Modification of Development Consent

Development consent: SSD 9874 granted by the Independent Planning Commission on 27 November 2020

For the following: Walla Walla Solar Farm

Modification: **SSD-9874-Mod-1:** Increase in solar panel height

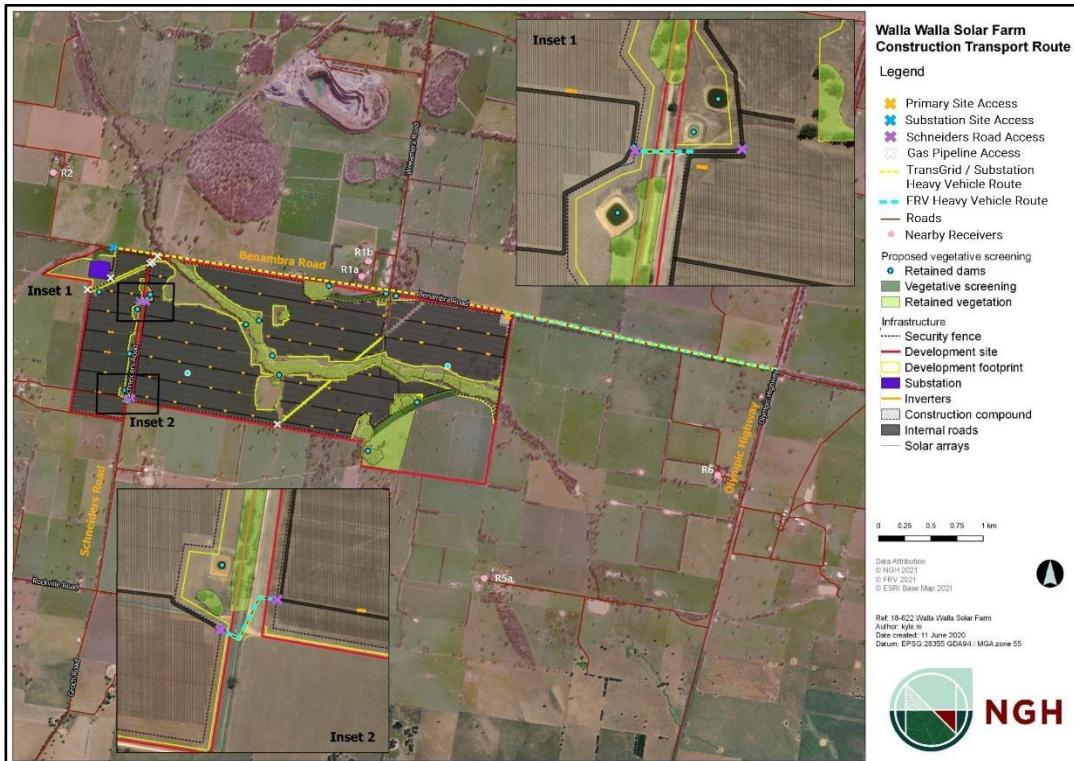
, or by 31 July 2022, whichever is the later;
7. In Appendix 5: Over-Dimensional and Heavy Vehicle Access Route Restrictions, replace the map with the following map:
